Please ask for: Ms Iqraa Malik
Email: iqraa.malik@terraquest.co.uk
Telephone: 0121 234 1390
Our Ref: EP/167/21/HH
Your Ref:
Date: 4th January 2022

Application for Planning Permission for Works or Extension to a Dwelling

Development: Erection of single storey rear and side extensions with mono pitched roofs and installation of fencing to front and side.
Location: 2 Vicarage Lane East Preston BN16 2SP

Block Plan

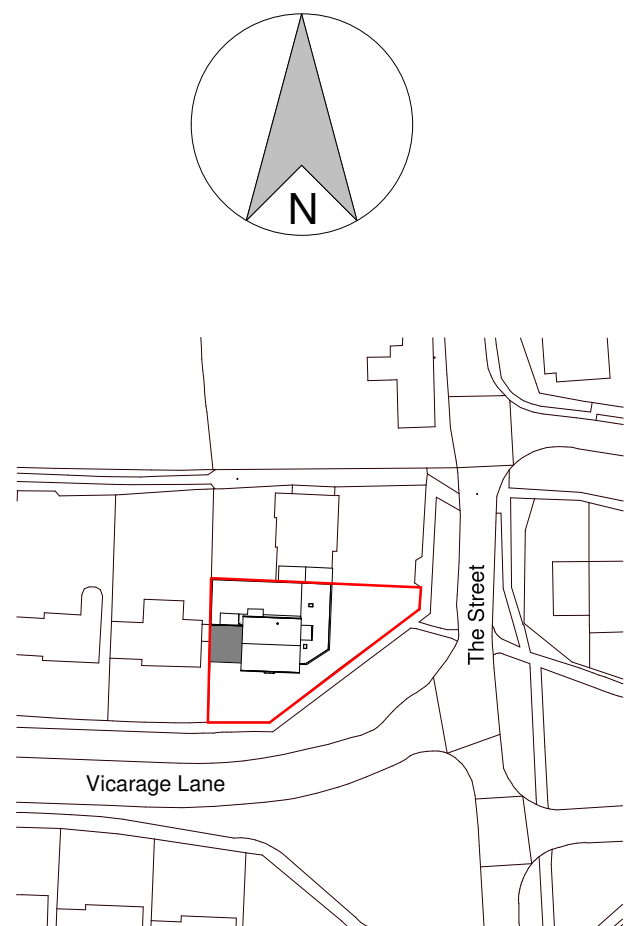
Block Plan

You are required to have dimensions from the proposed extension(s) to all site boundaries. Please amend.

Client	Mrs Grace Morgan
Project	2 Vicarage Lane
Sheet	Fence Elevations

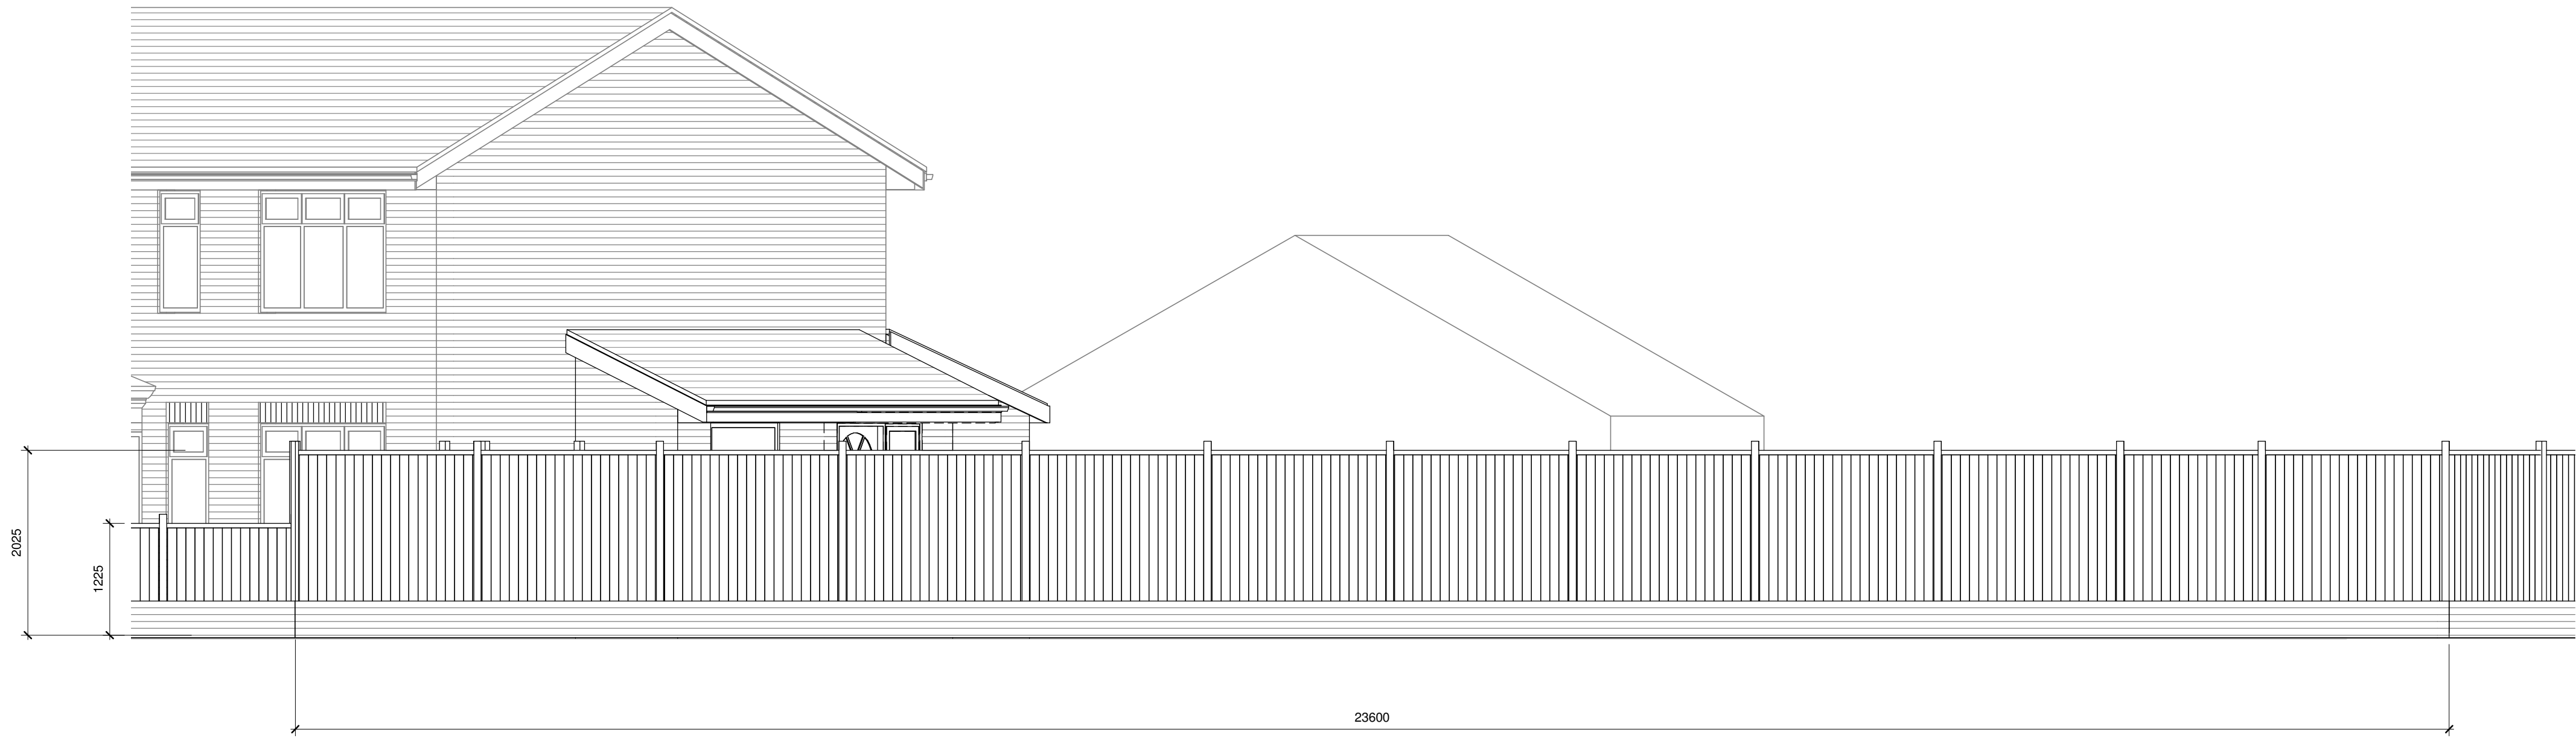
Elevations

Please submit the proposed fence elevations at a scale of 1:50 or 1:100. Further details can be found in the Validation Requirements List.
